POENITSCH SUBDIVISION

SUBDIVISION OF THE S1/2, SE1/4, SE1/4 SECTION 8, T.12S., R.65W. OF THE 6TH P.M.
EL PASO COUNTY, COLORADO

OLIVER E. WATTS CONSULTING ENGINEER COLORADO SPRINGS PCD FILE NO. MS193 9-26-19
DEW 18-5184-06

Final Plat_V2.pdf Markup Summary

POENITSCH SUBDIVISION

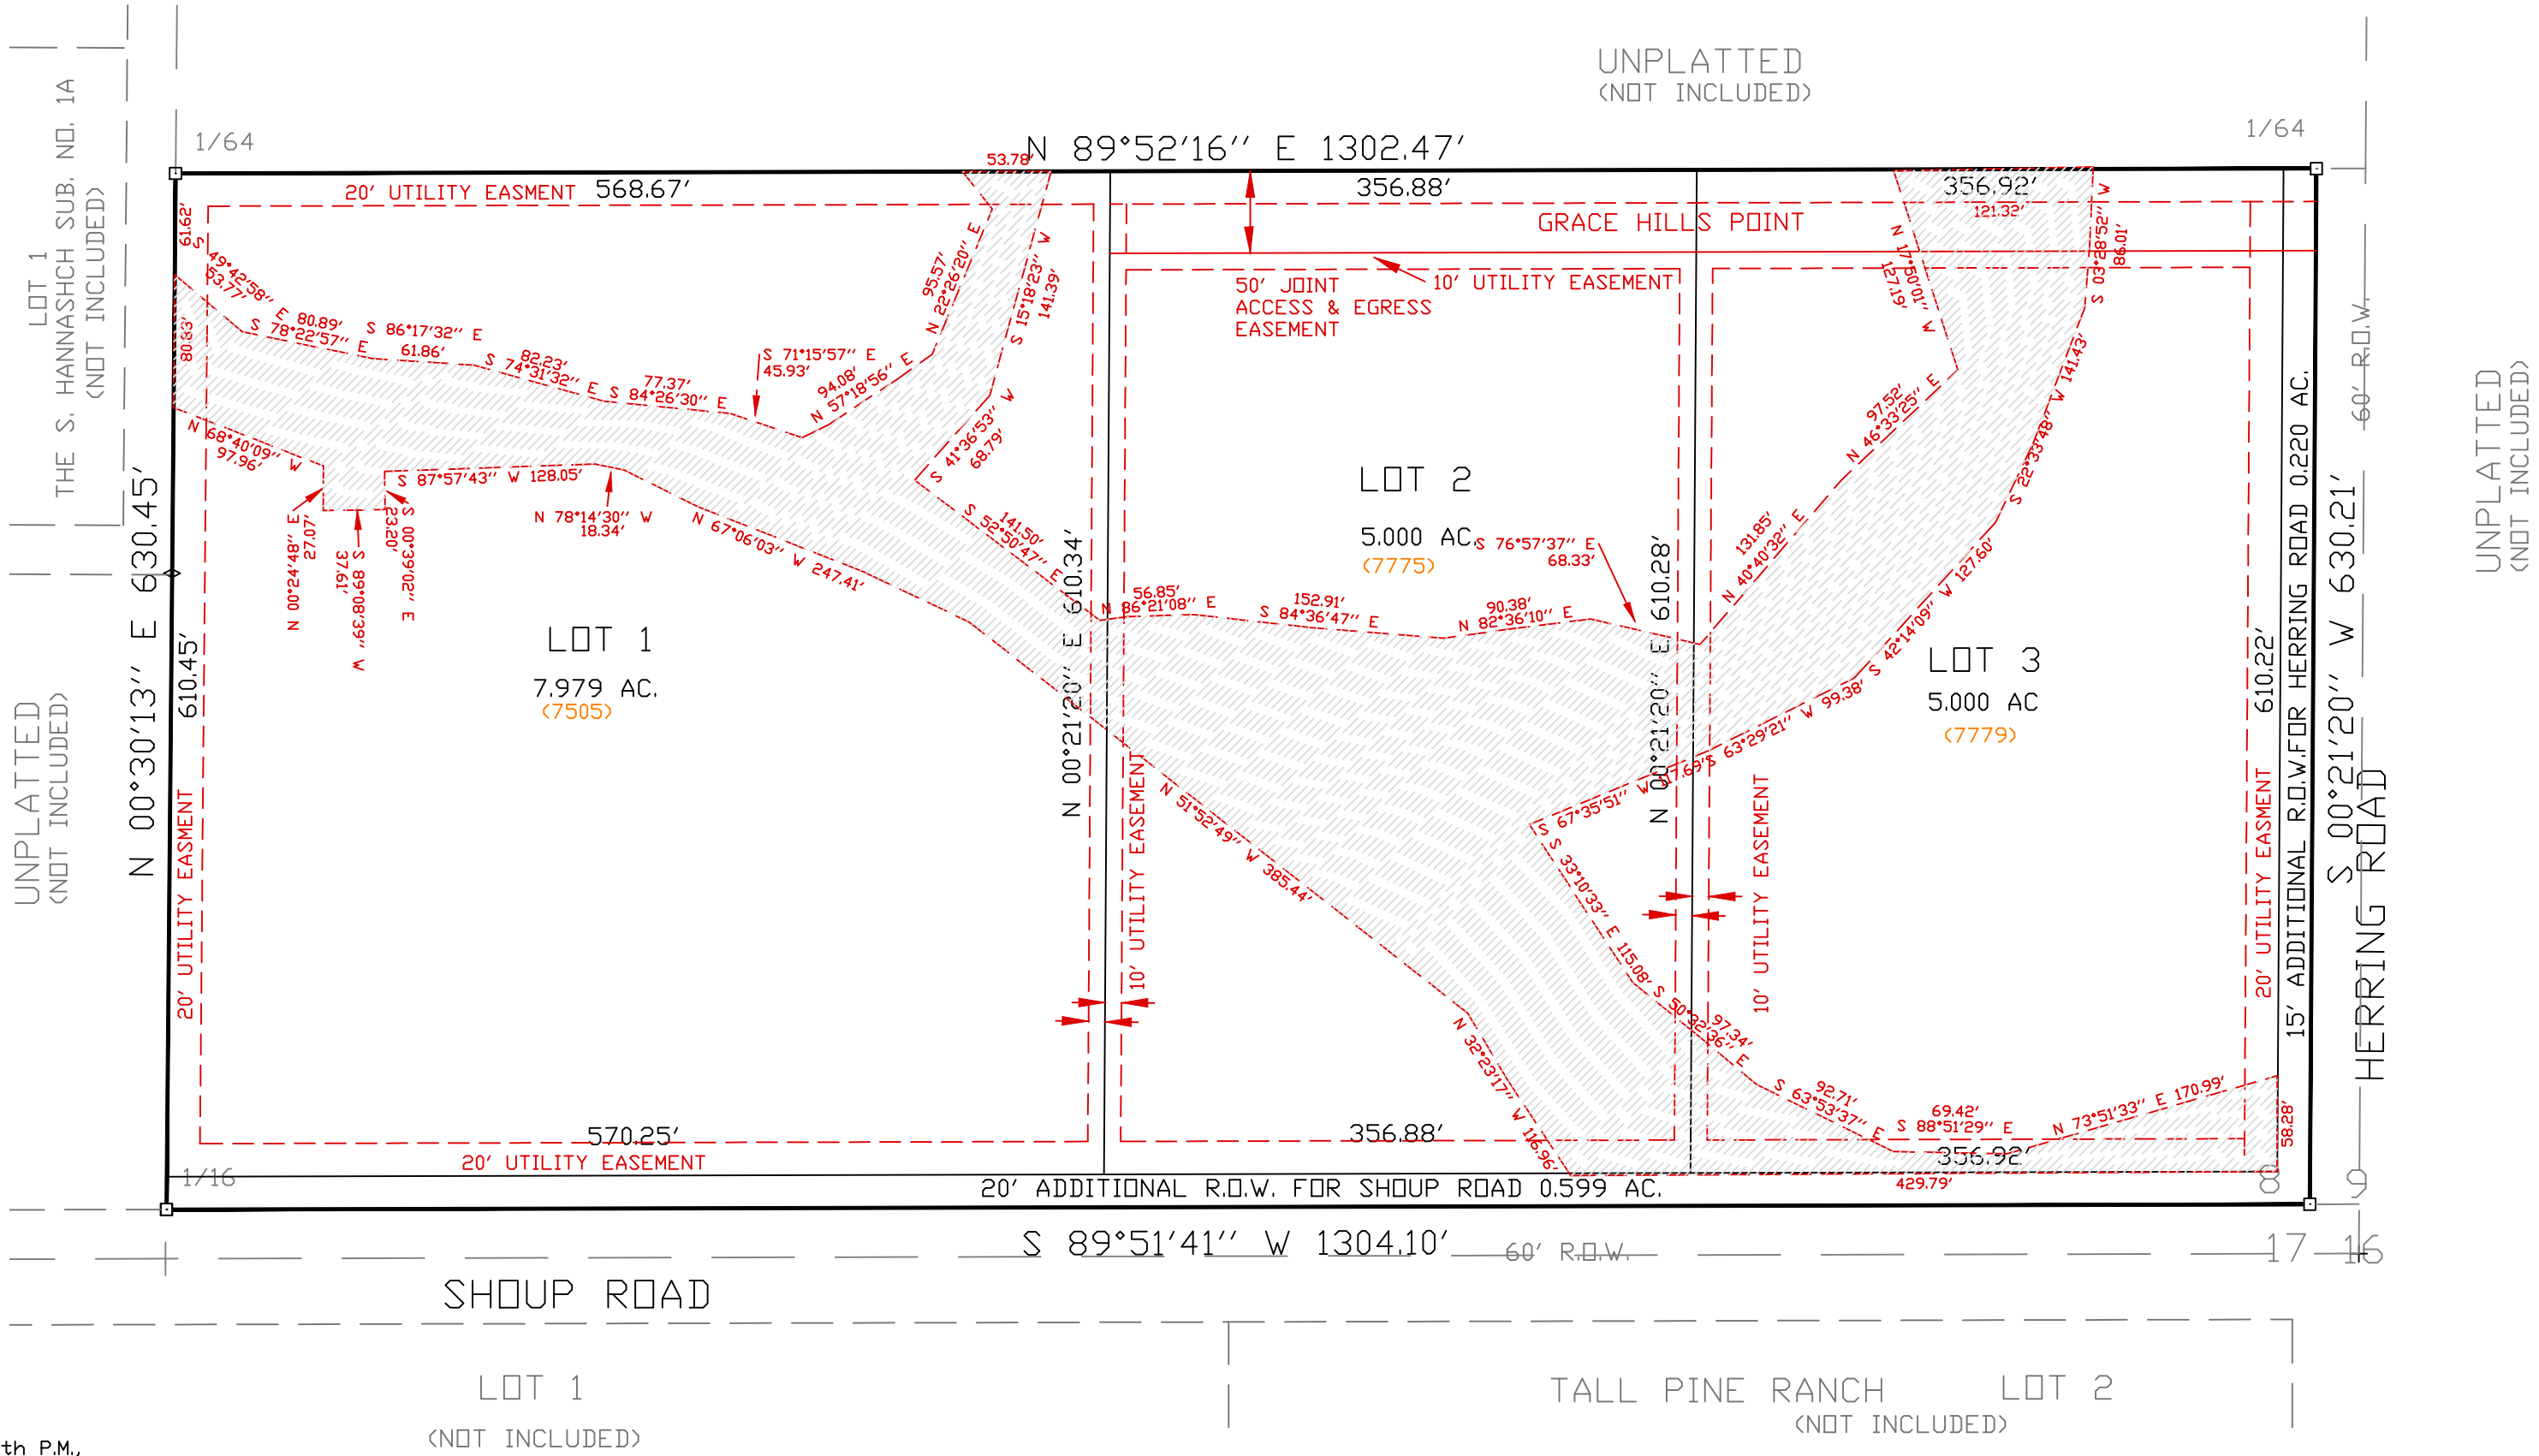
The access easement must be contiguous through the lots from the public ROW to the western property line of Lot 2.

Unresolved. Update the access easement linework as a continuous line from Lot 1 to Herring Road. See example below

This acreage for the ROW dedication does not appear to be correct. Please revise.

Unresolved.

Provide bearings and distances for the drainage easement.

Revise to "Public Drainage Easement with No-Build and No Storage of Materials. The sole responsibility for maintenance being vested with the individual property owners."

Missing the water surface elevation.

Increase text size on all channel sections to be legible. Staff recommends moving the text to the side of the hatching for clarity.

Add all line types used in the legend.

increase text sizes.

Revise the first sentence to "There shall be no direct lot access to Shoup Road."

Adjust easement so the 100yr wsel is inside the drainage easement.

Easements do not meet standards for rural density of 10 feet, also see MVEA comments for easements.

Unresolved- The easement for access and egress needs to have a plat note with the reception number that it was recorded under, also there needs to be a plat note to describe that 911 requested the name, but that it is still a driveway and not a public or private road, and will be maintained by the HOA.

reception number for access and egress easement required under plat note.
